RHS further comments on HE's Further Response to RHS's Response to REP3-044

MERGE (SOUTH SLIP)

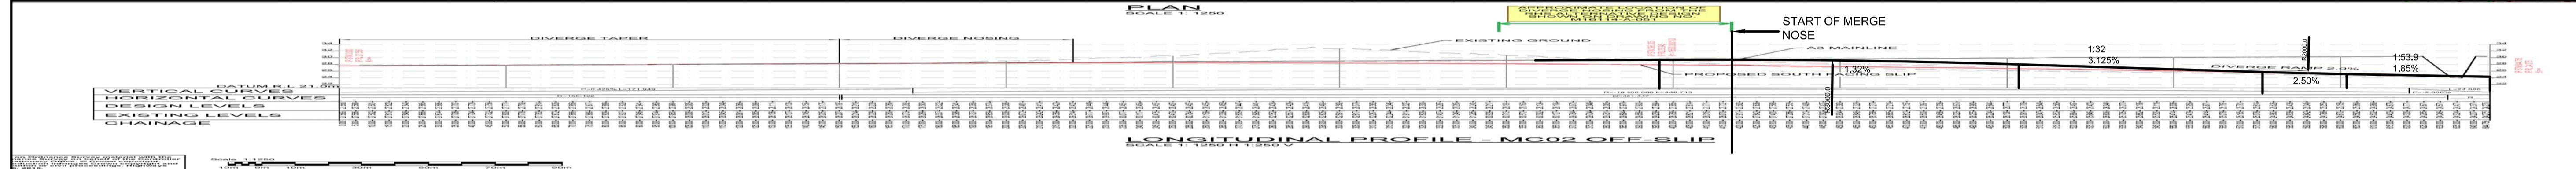
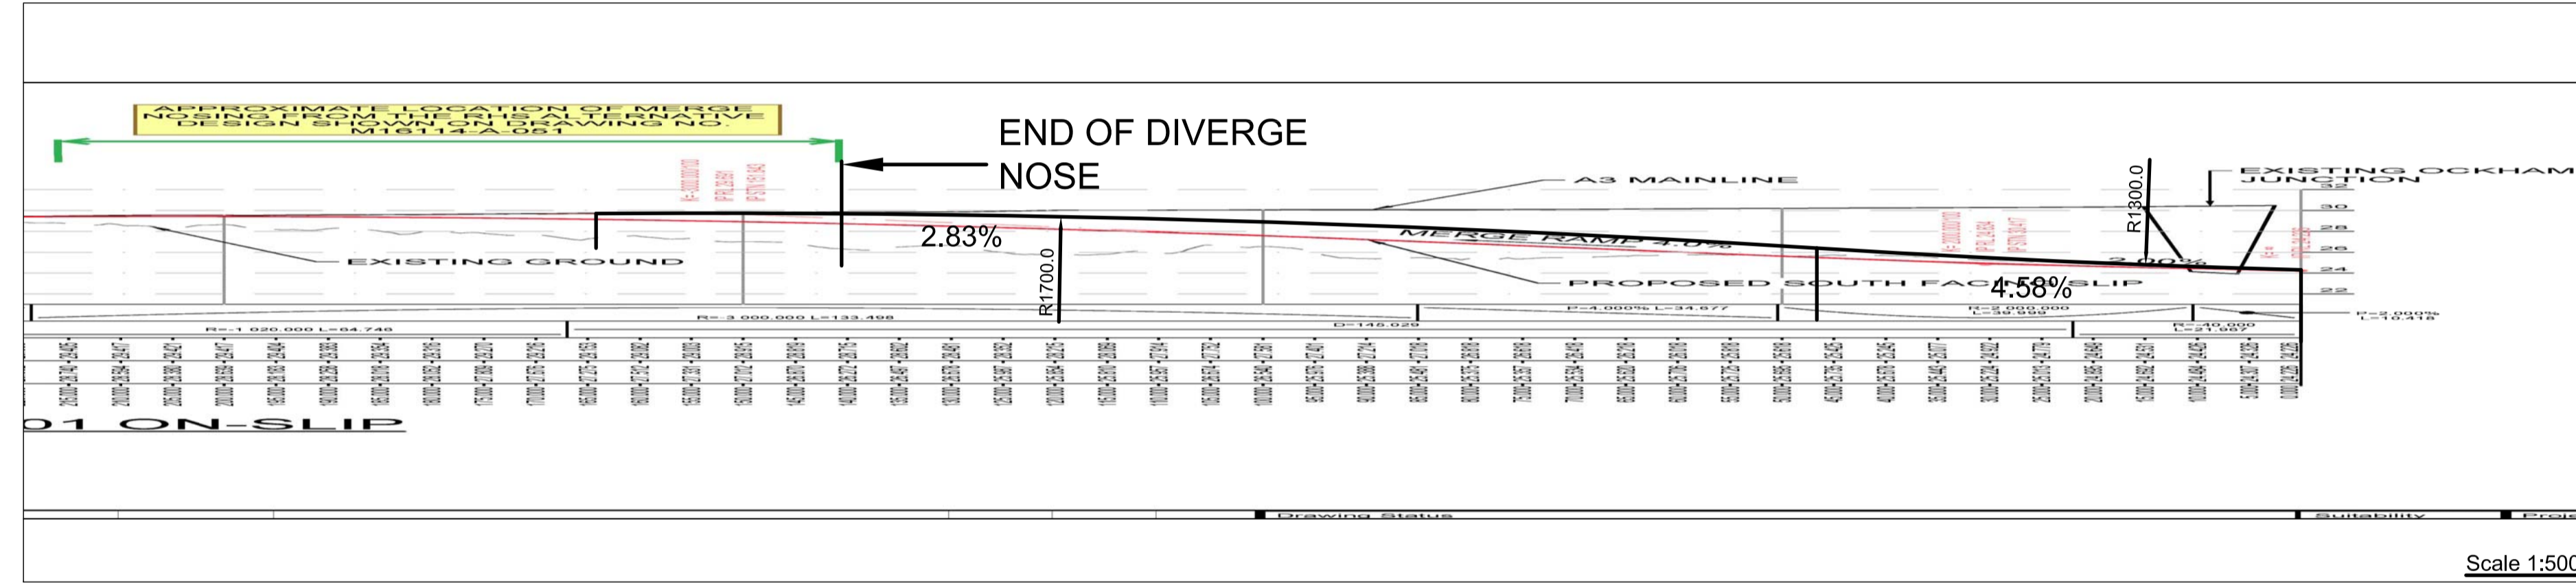
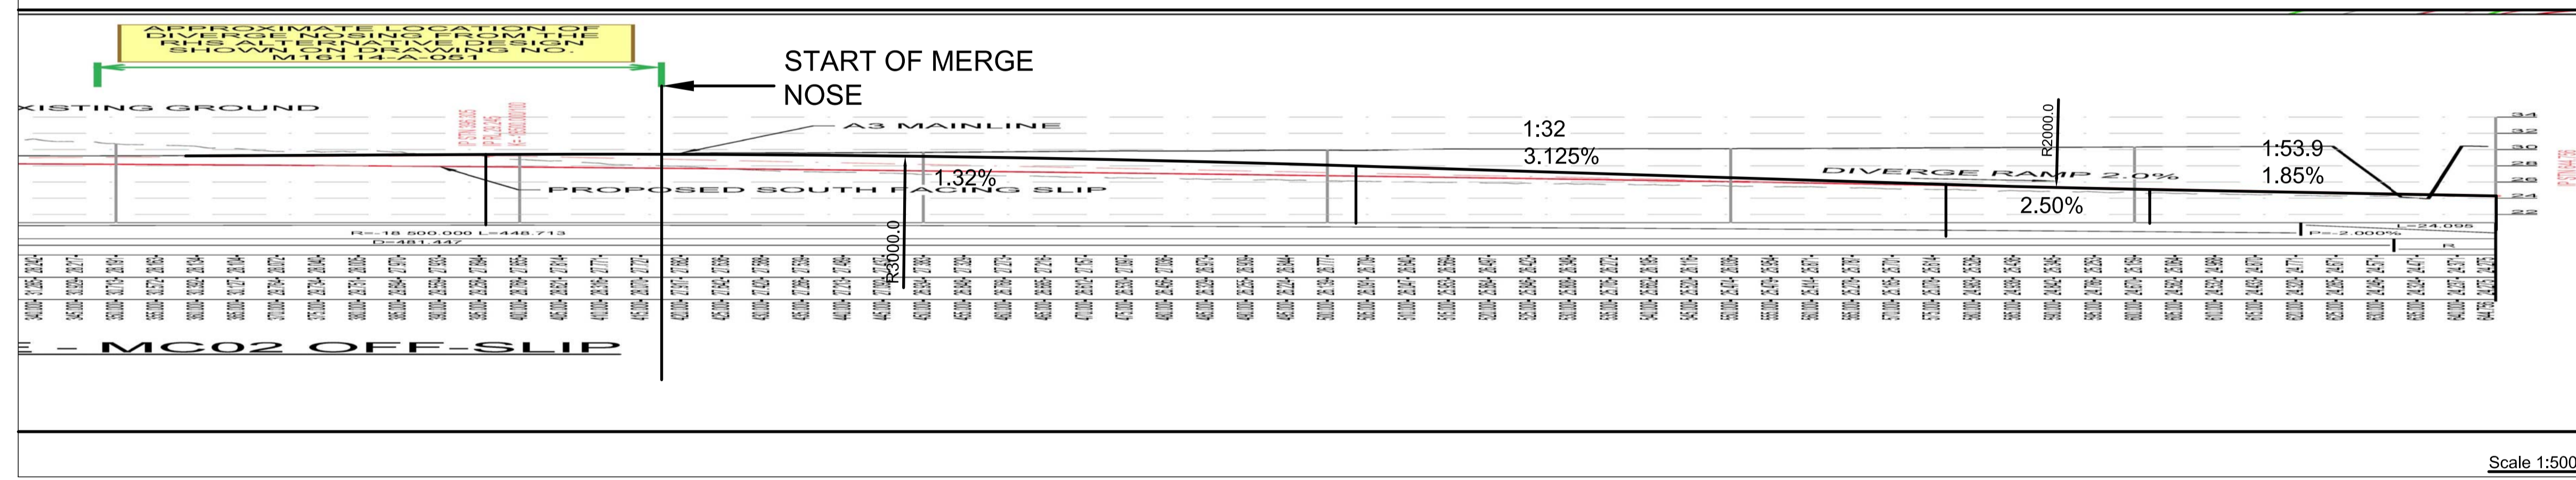
The horizontal curvature (radius) of the Wisley Lane slip within the RHS Alternative Scheme adopted a radius which exceeds the radii of three or the four 'slip road to slip road' components of the DCO Scheme J10 improvement.

HE has suggested that a larger 90m radius is required for the Wisley Lane slip in accordance with Connector Road provisions but is seemingly not requiring that of their own design at J10. A 90m radius could be accommodated whilst still delivering the 1km minimum weaving distance.

<p>particularly because the vehicles merging from Wisley Lane will be slow moving.</p> <p>Highways England maintains that TD42/95 is the design standard for Major/Minor priority at grade junctions, which is what this particular element of the Scheme should be, but the design standards do not allow this type of junction on Dual 3 lane All Purpose (D3AP) roads and therefore by implication it is not permitted for use on Dual 4 lane All Purpose (D4AP) roads. As proposed by RHS, Highways England maintains that CD122 is not the correct design standard to be used for the RHS Alternative Scheme.</p>	<p>In respect of the weaving distance to Ripley Services, TTHC drg M16114-A- 051 shows one means of how the 1km weaving distance could be achieved for both directions of travel on the A3.</p> <p>Improved Wisley Lane connection to A3 Northbound</p> <p>The review of the proposed RHS Alternative Wisley Lane connection to the A3 Northbound against highway standards is currently subject to SoCG discussions. At this stage the parties continue to disagree.</p> <p>Within REP1-044, TTHC provided a response to the Applicant's position in respect of this matter.</p> <p>Confirmation that Wisley Lane will be subject to a 30mph speed limit in the DCO Scheme will enable the standard applied by TTHC to some components of the RHS Alternative to be less onerous than that assumed to date</p>	<p>comments on the RHS Alternative Scheme in Section 3 above.</p> <p>The parties are continuing to discuss this matter, however Highways England's position remains that this arrangement would be non-compliant and unsafe.</p>	<p>Departures from Standard in respect of the southbound on-slip 'Nose Length' and potentially in respect of 'Near Straight' components. It is expected that the existing laybys between Ripley Services and the South Facing Slips would be removed.</p> <p>Further discussions have taken place between RHS and HE in respect of design matters associated with the Wisley Lane connection to the A3 Northbound carriageway.</p> <p>Since the original RHS Alternative was developed, design standards have been amended (from TD22 to CD122, which was published in Sep 2019). CD122 has different requirements in respect of some components of the Wisley Lane slip. The two which have a bearing on the RHS Alternative are the 'Near Straight' and 'Horizontal Curvature' components.</p> <p>The CD122 Near Straight design standard seeks a near straight section of at least equal to the Nose (in this case 85m) to be provided at the back of the nose. The RHS Alternative scheme would be subject to a Departure from Standard.</p> <p>The need for a Departure is not</p>
